**RE: BERNALILLO COUNTY COURTHOUSE (J14-D120). DRAINAGE REPORT AND CONCEPTUAL GRADING AND DRAINAGE PLAN FOR PRELIMINARY PLAT AND SITE DEVELOPMENT PLAN FOR BUILDING PERMIT. ENGINEER'S STAMP DATED 10-13-97.**

Based on the information provided on your October 14, 1997 submittal, the above reference project is approved for Site Development Plan for Building Permit only. City Hydrology has the following comments prior Preliminary Plat approval:

RECEIVED			
OCT 14 1997			
HYDROLOGY SECTION			
COUNTY OF BERNALILLO, NEW MEXICO			
BERNALILLO COUNTY COURT HOUSE			
CONCEPTUAL DRAINAGE PLAN			
ANDREWS, ASBURY & ROBERT, INC.			
CONSULTING ENGINEERS			
FILE NO.	DRAWN	CHECKED	DATE
97-782	MS	PG	OCT. 1997
			MAP NO. 2

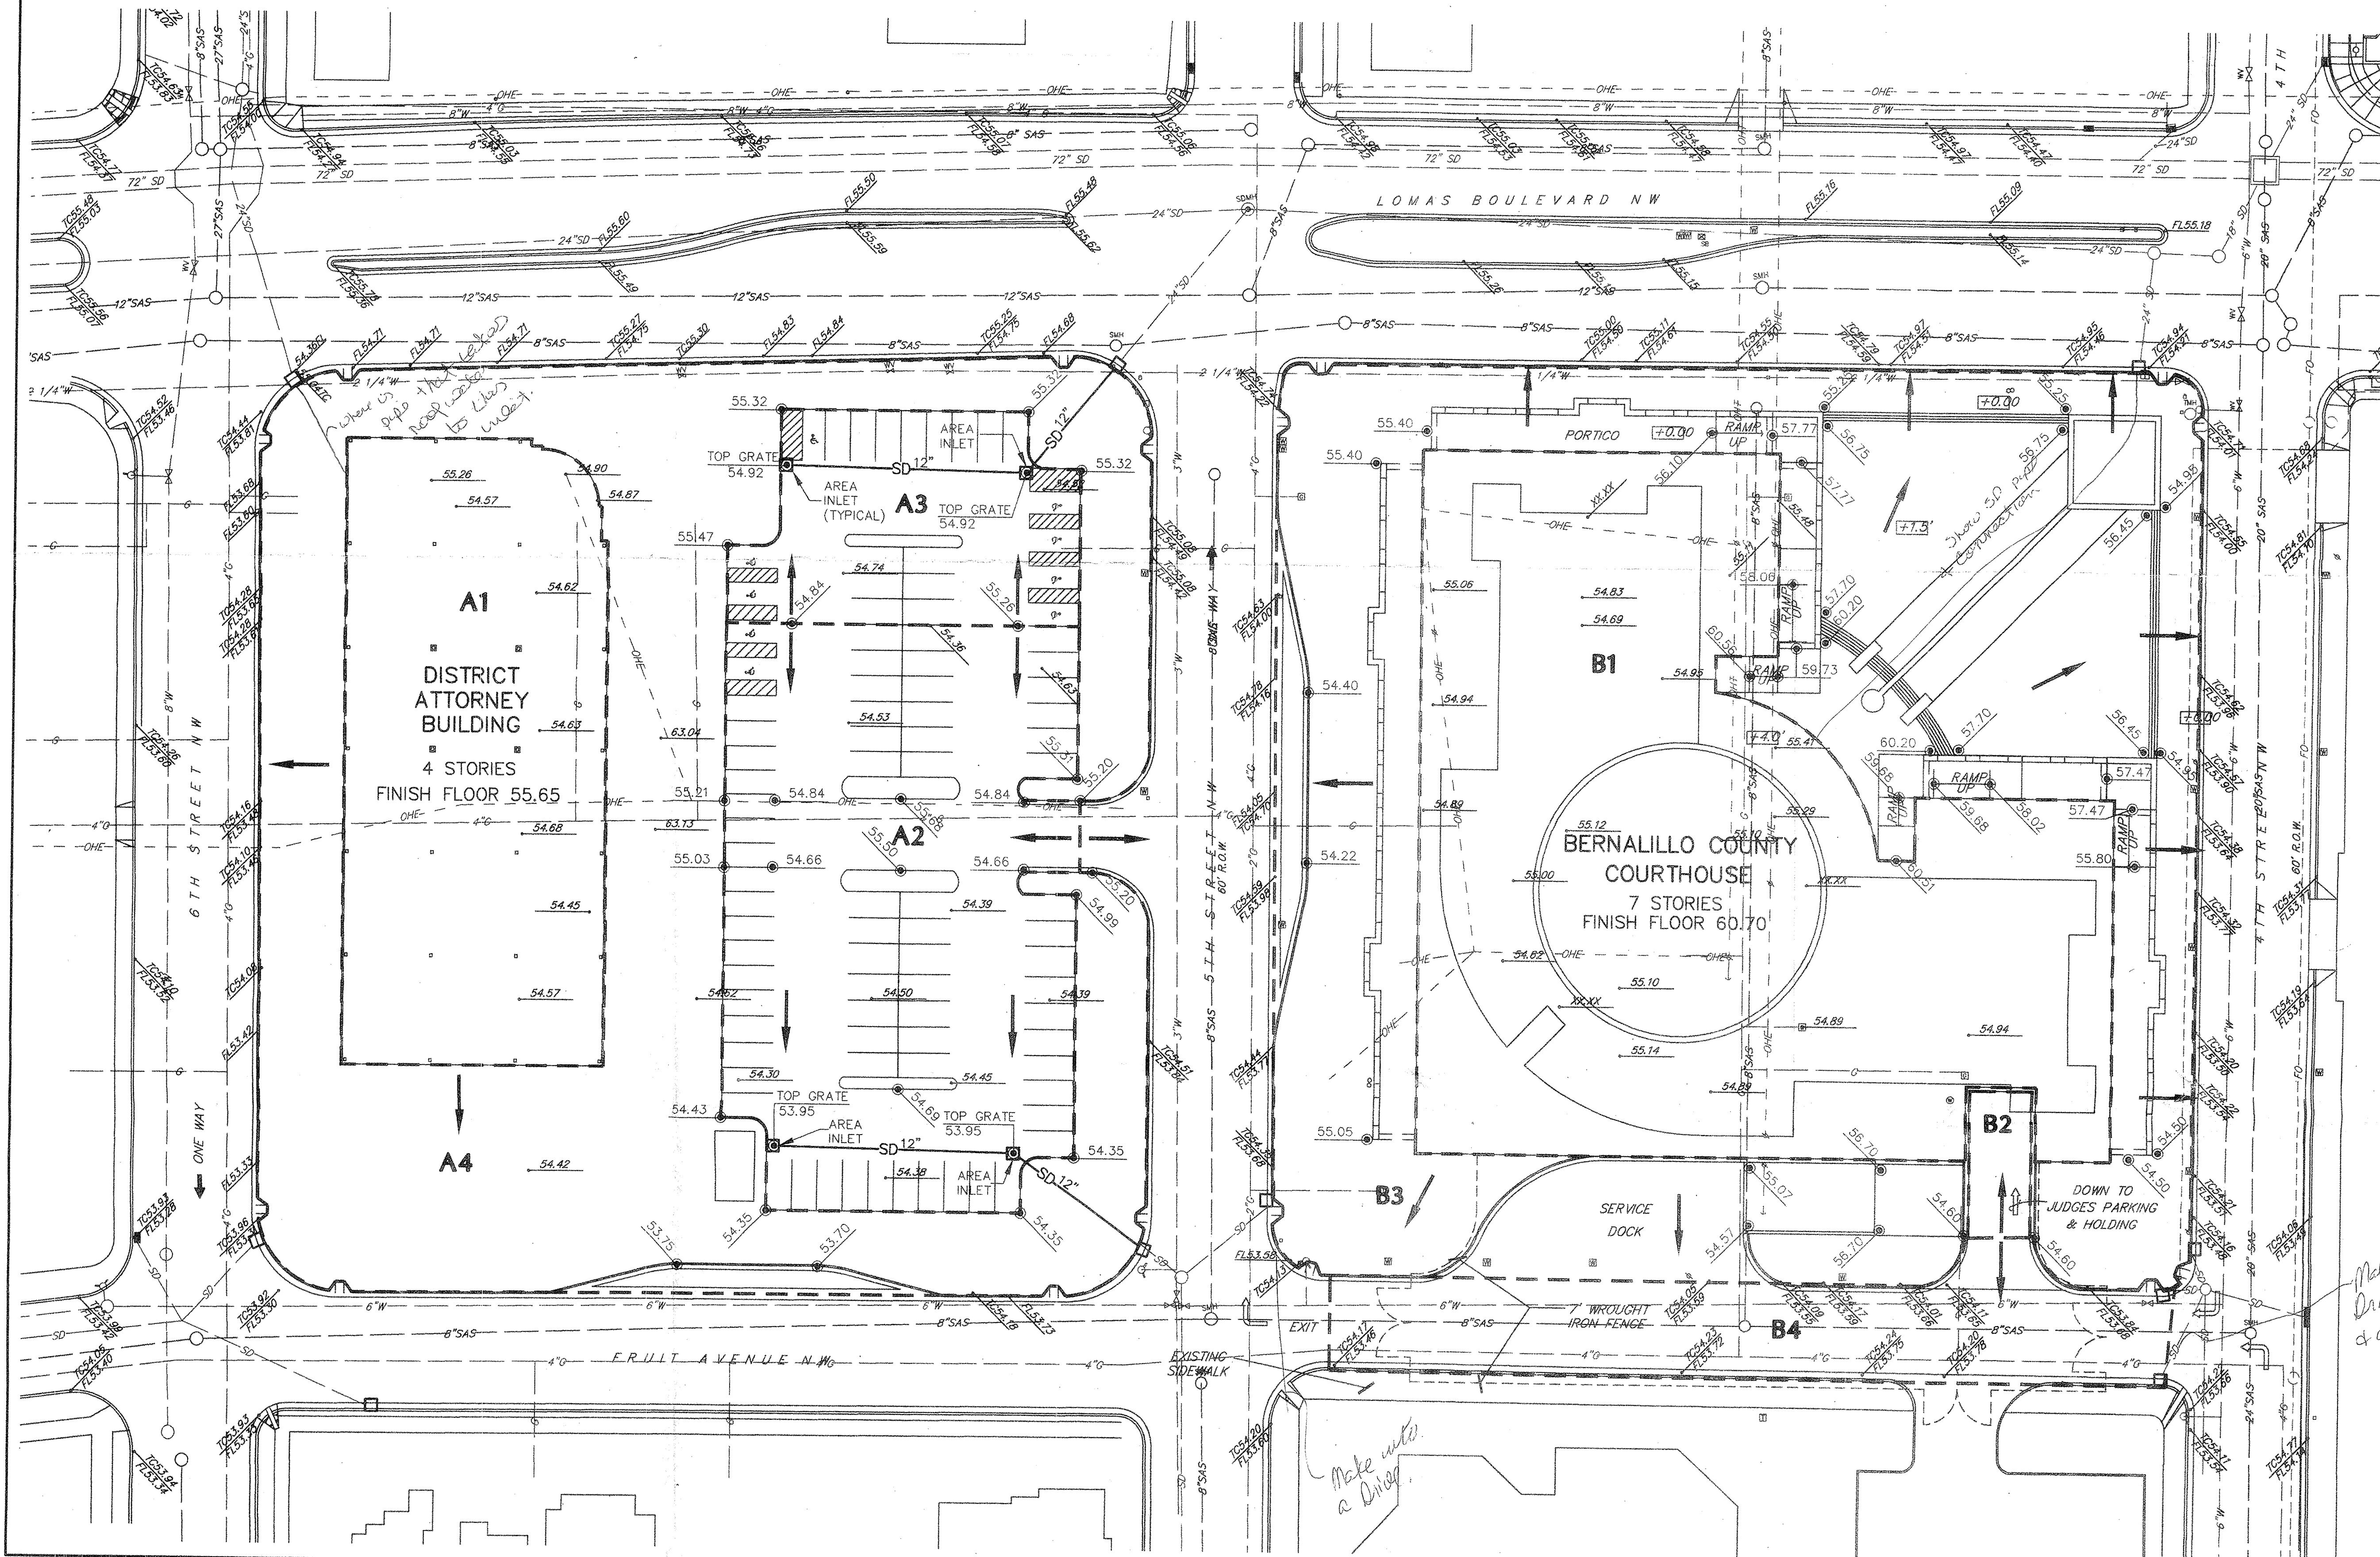
2. Provide inlet and storm drain capacity calculations.
3. Show the storm drain pipe that takes the roof flow to the inlet.
4. Label proposed and existing inlets and manholes on the legend. I am having a difficult time determining what you are installing, and what is existing.

5. If Fruit Avenue is to be vacated, you will be required to install driveways (cannot use existing curb returns) and a one foot water block. No public storm water may enter the vacated Fruit Avenue.
